Your Ref :  
Our Ref : M/106/18/NMA

**Application for a non-material amendment following a grant of planning permission M/84/16/PL relating to amending the style of windows from geo bar to plain**  
**172 Elmer Road, Middleton-On-Sea, ,**

Date	Drawn by	Scale
August 2017	CDP	as shown
Revision		
BR-01		03

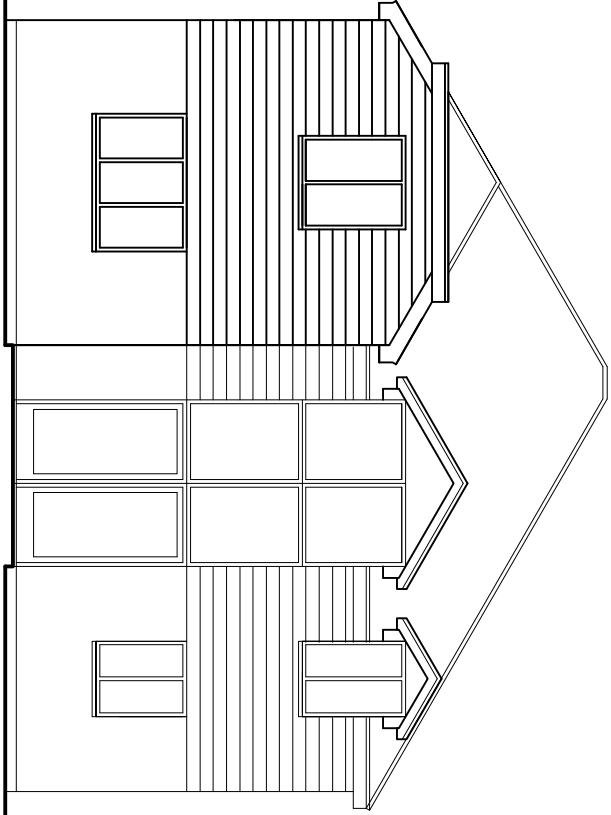
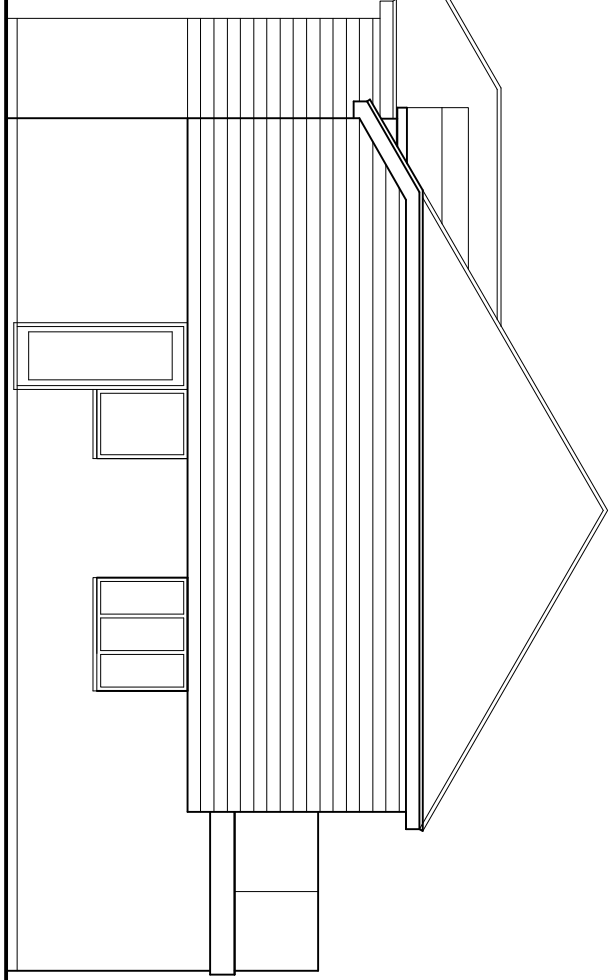
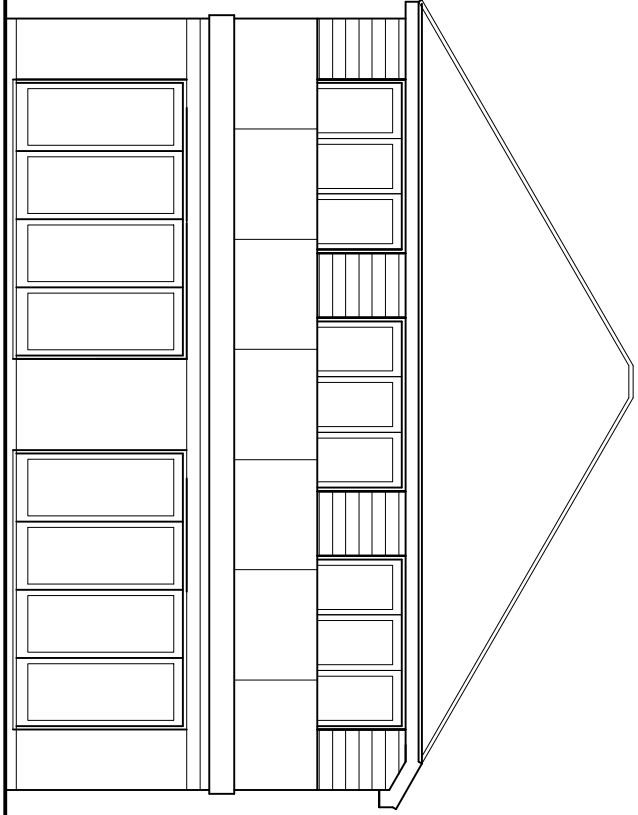
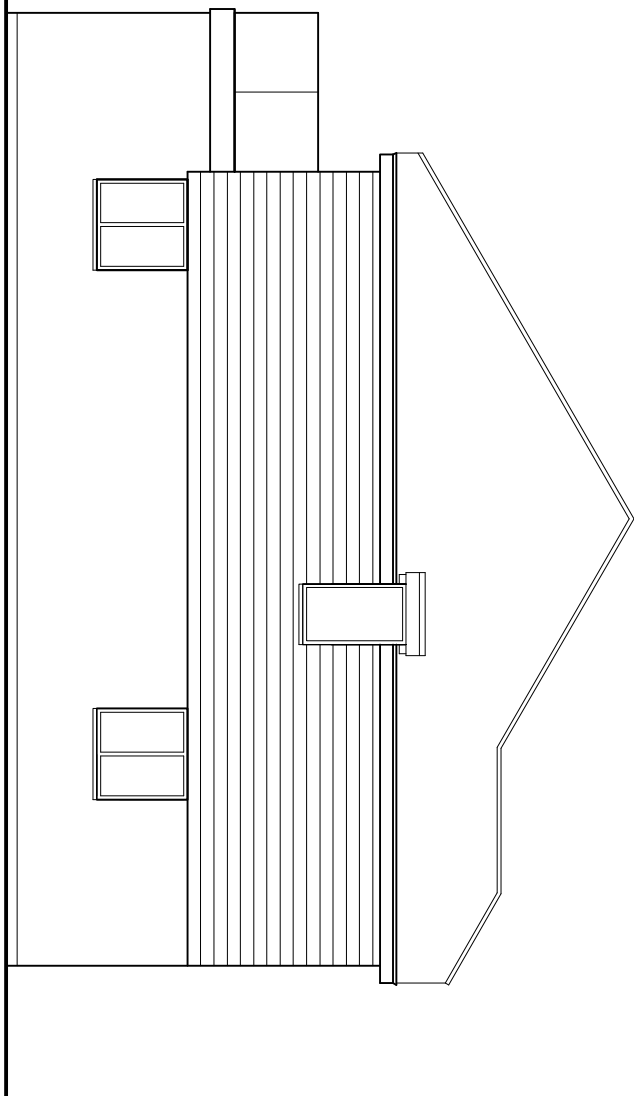
From the information submitted I am able to take the alterations to the window design involving change from the approved geo bar style to slimline frames as a Non Material Amendment to M/84/16/PL. Drawing number BR-01 rev03 has therefore become the approved plan for planning approval M/84/16/PL.
